Moorebank Intermodal Precinct West – Concept Plan and Stage 1 Modification 2 (SSD-5066-Mod-2) and Stage 2 Modification 1 (SSD-7709-Mod-1) – Response to Submissions

Attachment 1 – Key Issues Raised:

2 PRECINCT PLAN - SSD 5066 MOD 2
- PROPOSED SCALE 1:5000 @ AD

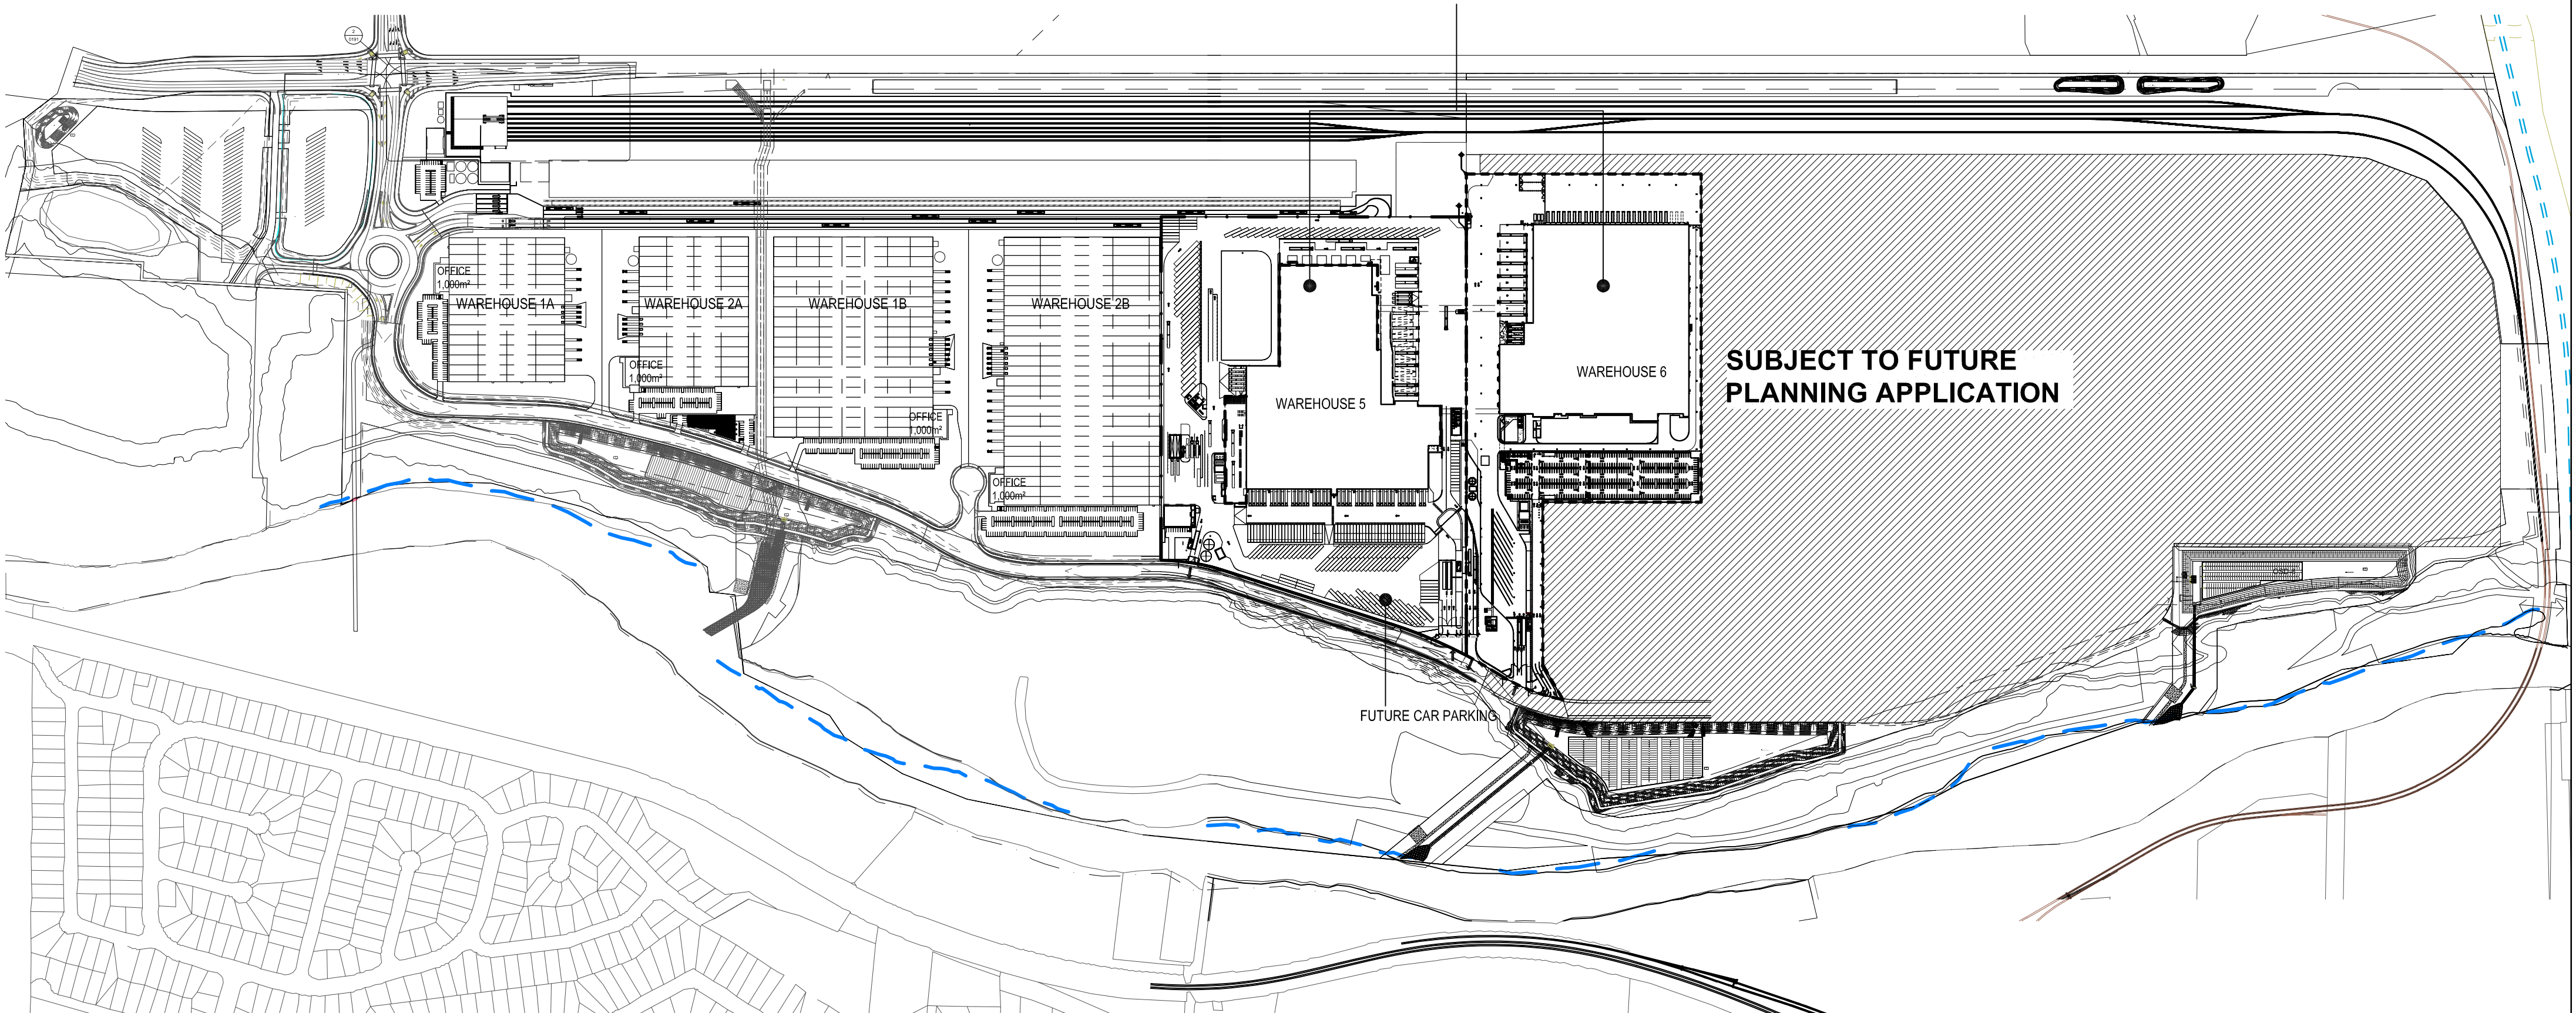
The proposed increase in building heights for warehouses 5 and 6 is a key concern raised during the exhibition of the modifications, which the Department requests you address. Additional information required to address these concerns should include, but not be limited to:

- Further justification of the proposed 45 m heights and subsequent non-compliance with the Liverpool LEP;
- Additional evidence to demonstrate that current approved warehouses height of up to 21 m would not be commercially viable (i.e. that the proposed height increase is required to ensure that the site is viable for future commercial operation);

- Clear plans/diagrams indicating:
 - a. the location of the subject warehouses in context of the other warehouses within SSD-7709 and other land uses around SSD-7709;

- b. the location of all dangerous goods and hazardous chemicals storages (class and maximum quantities) within the site plans of the subject warehouses and verify that this storage arrangement would be able to comply with the relevant Australian Standards; and
